CITY OF ALBUQUERQUE

December 21, 2018

**RE: Nuevo Atrisco- North Tract
Central and Unser NW
Grading Plan Stamp Date: 12/03/18
Drainage Report Stamp Date: 12/03/18
Hydrology File: K10D058**

CG-502  
OF

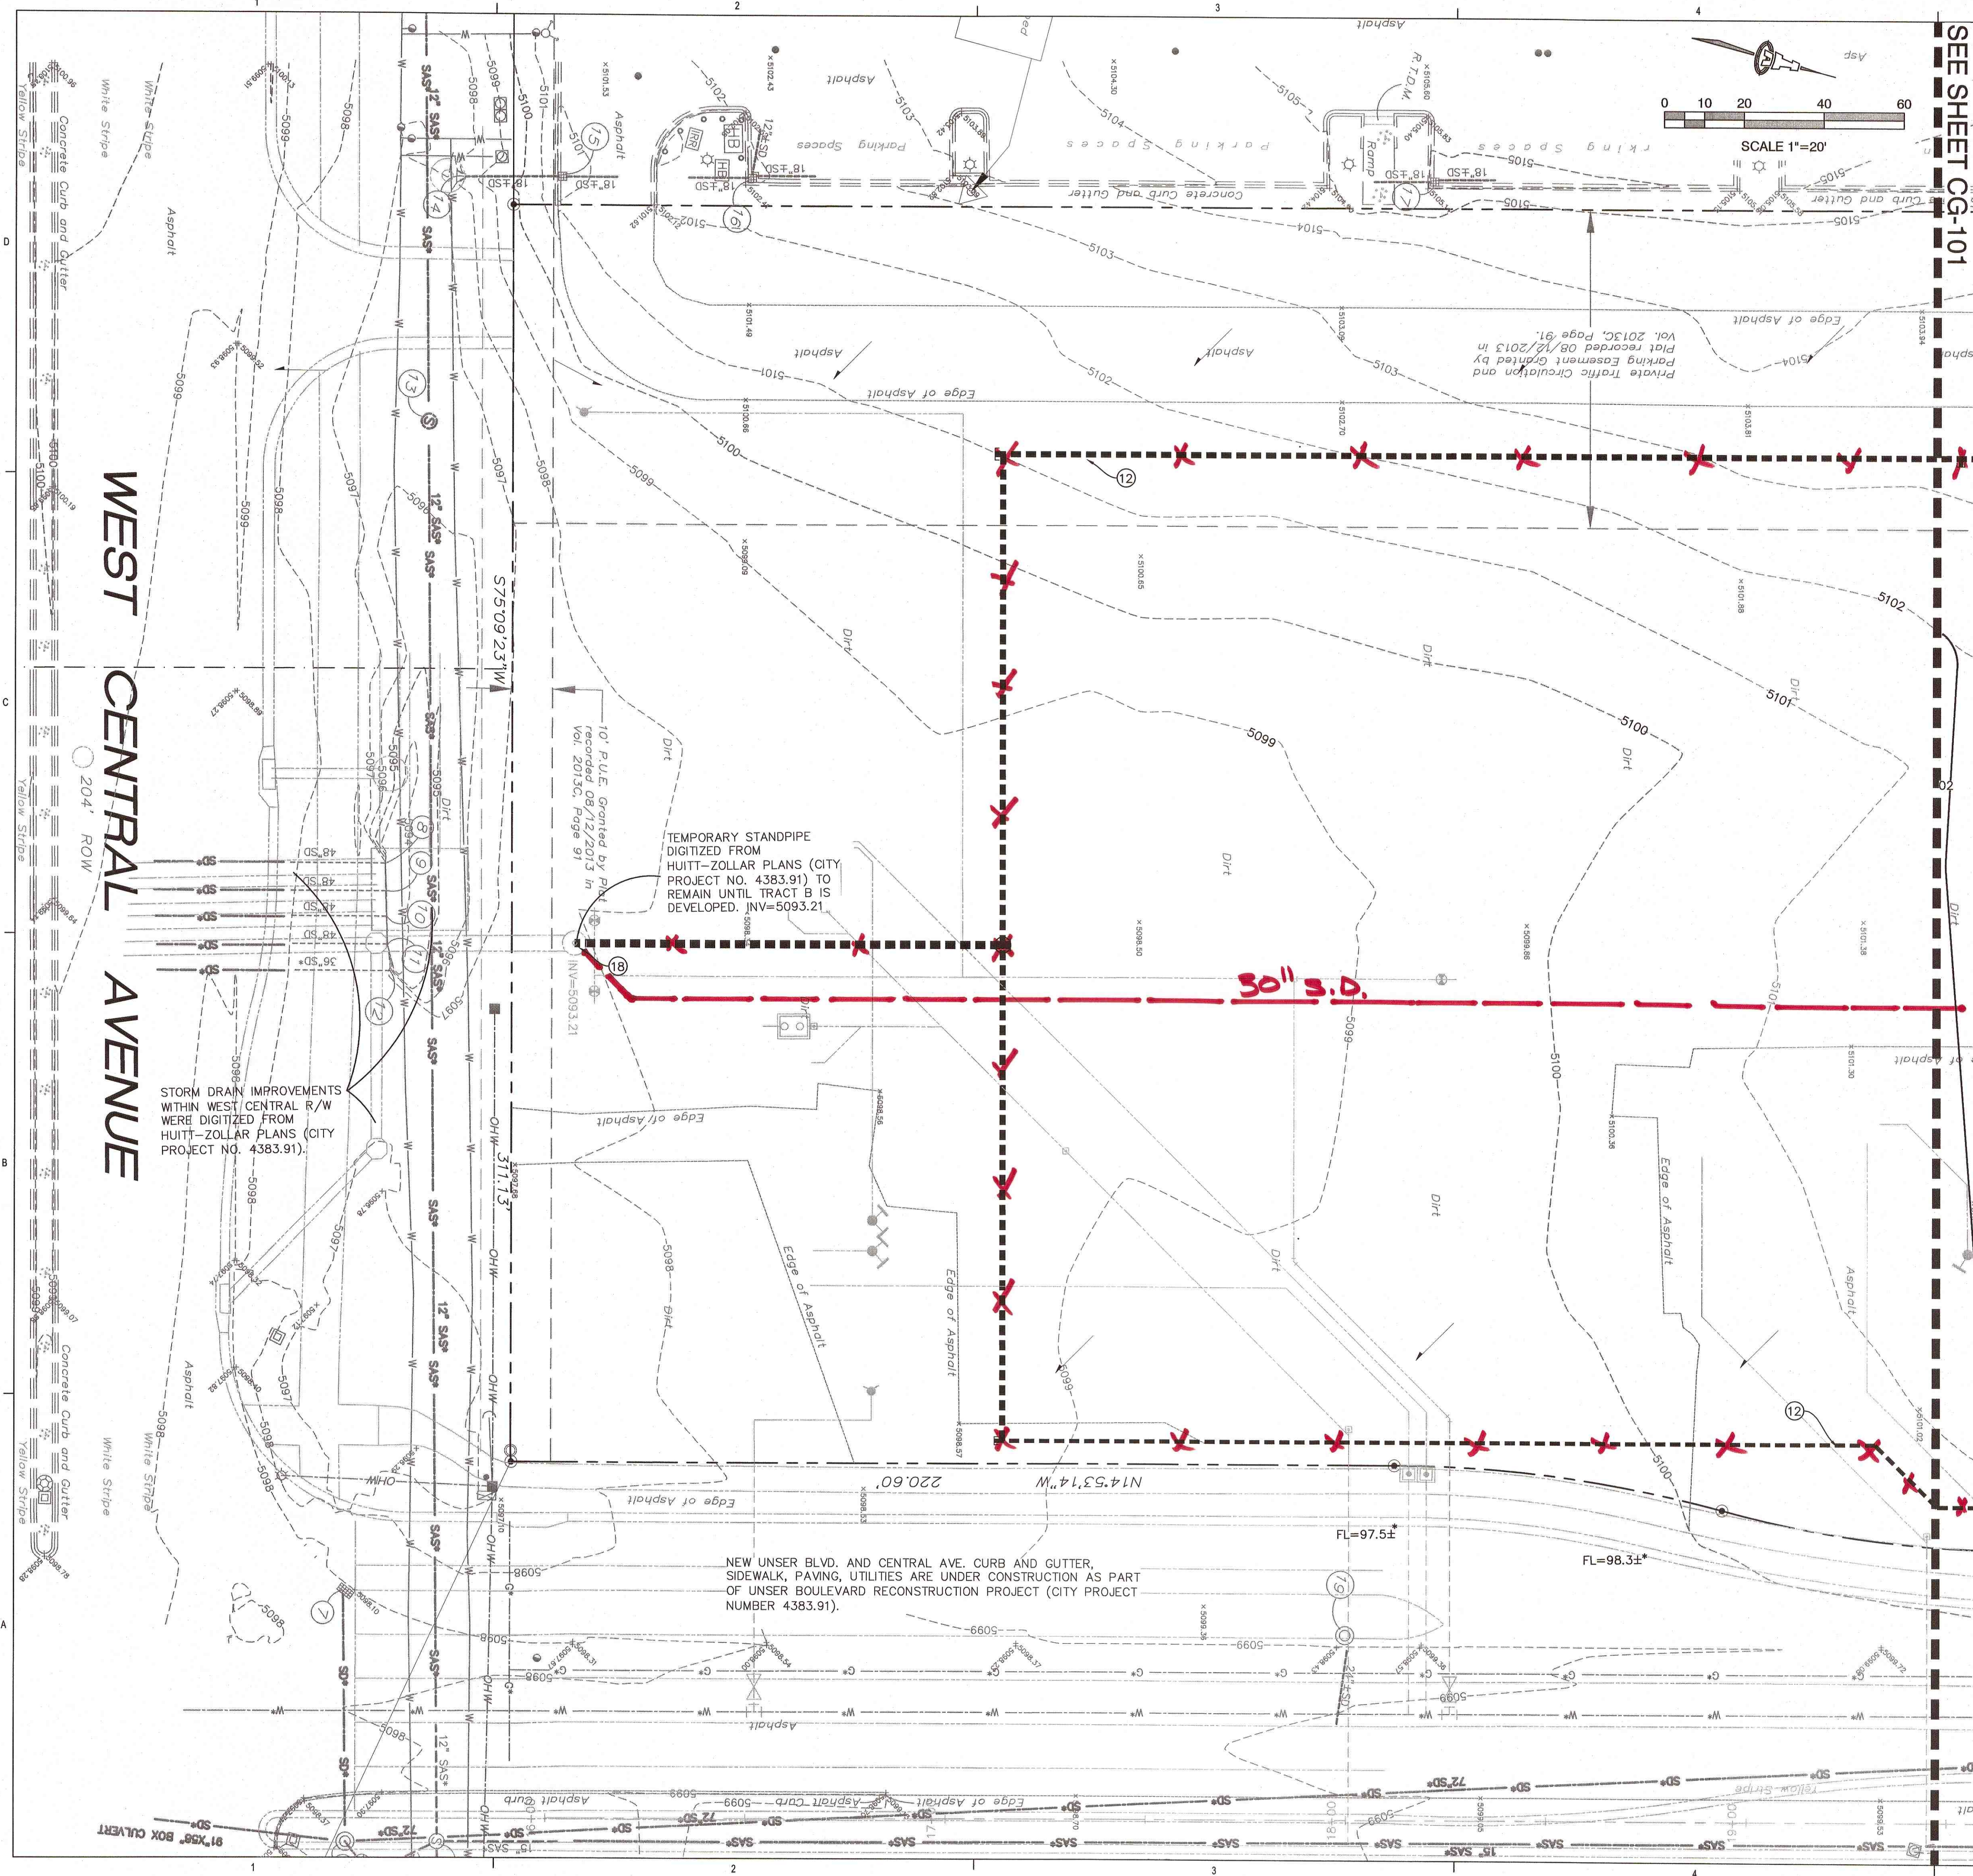
1. Engineer's Certification, per the DPM Chapter 22.7: *Engineer's Certification Checklist For Non-Subdivision* is required.
2. The downstream conveyance (private storm drain shown on sheet CG-502) across the southern tract to the connection on Central will need to be constructed with this tract and certified prior to C.O.
